DECISION NOTICE

Application Ref: FP/10/21/HH

68 Downview Road
Felpham
PO22 8JA

Single storey front porch extension and first floor extension over existing garage (Resubmission of
FP/196/20/HH)

sheet 2 a of 3

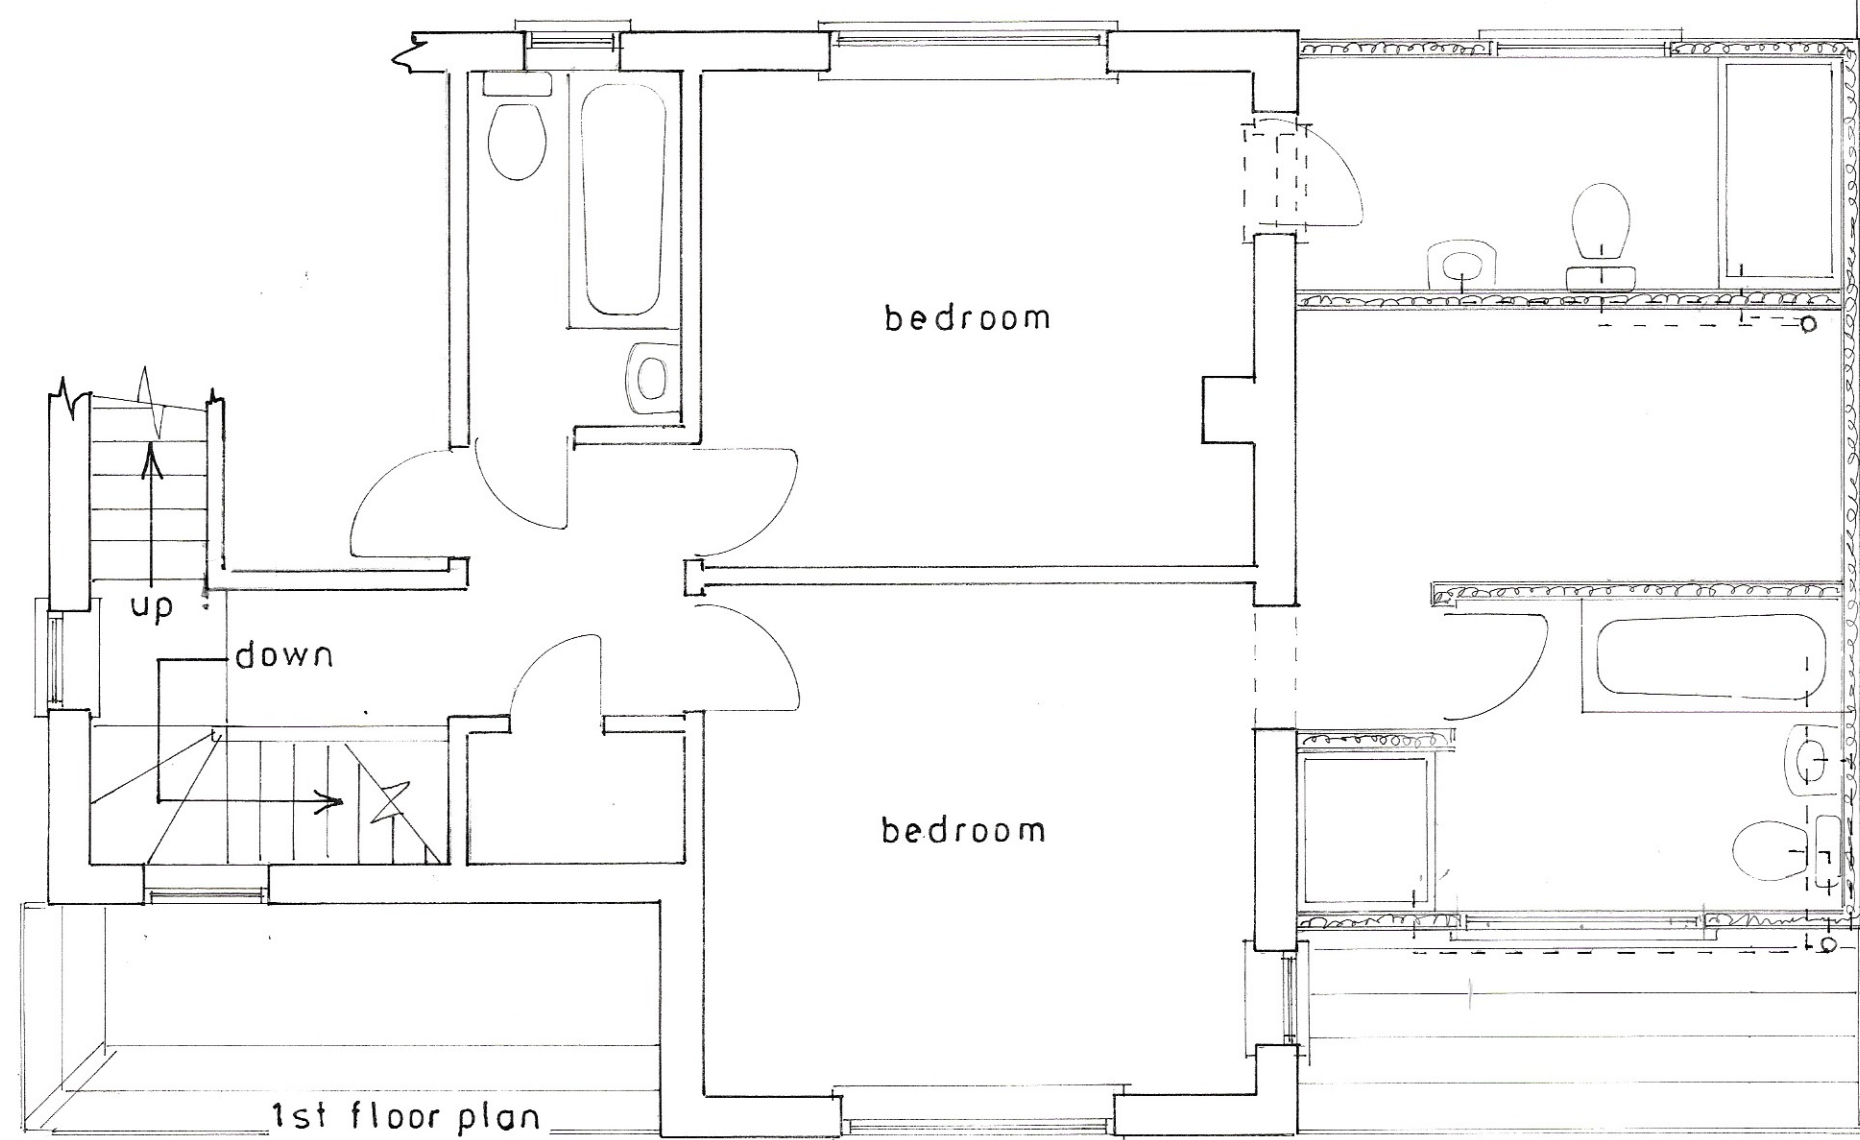
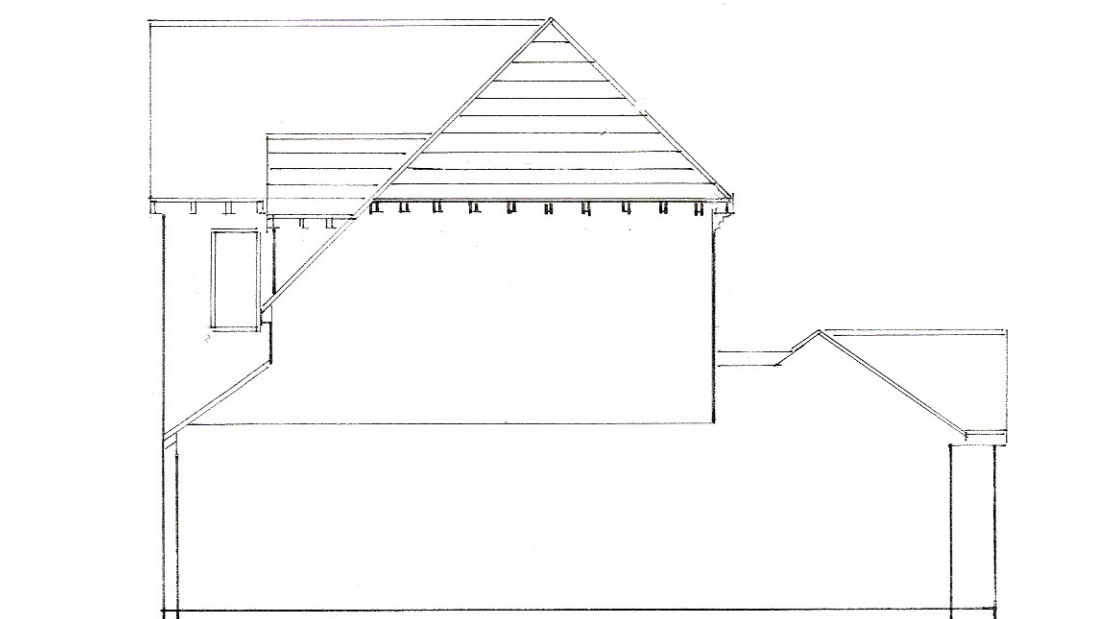
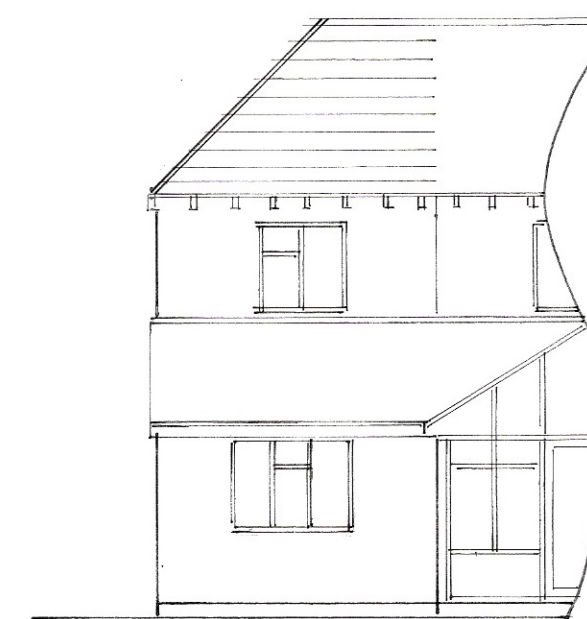
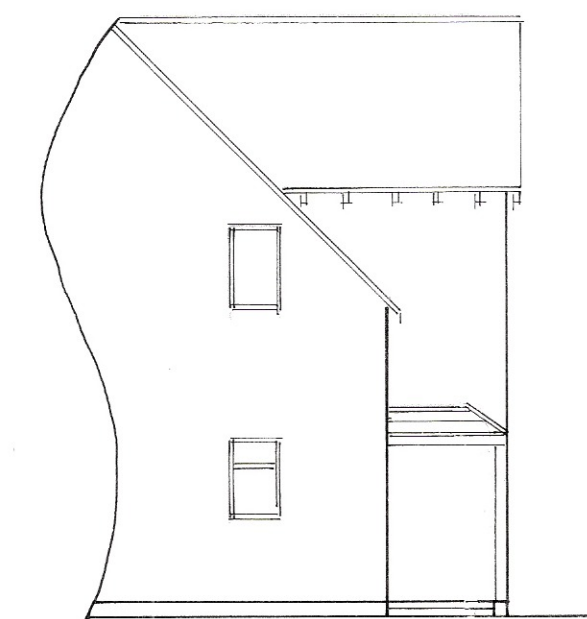
- 1 The extension to the side of the dwelling by reason of its scale and location has a detrimentally harmful impact upon the residential amenities of the property to the south due to its oppressive and overbearing impact in conflict with policies D DM1 and D DM4 of the Arun Local Plan, Paragraph M.01 of the Arun Design Guide and policy ESD1 of the Felpham Neighbourhood Plan.
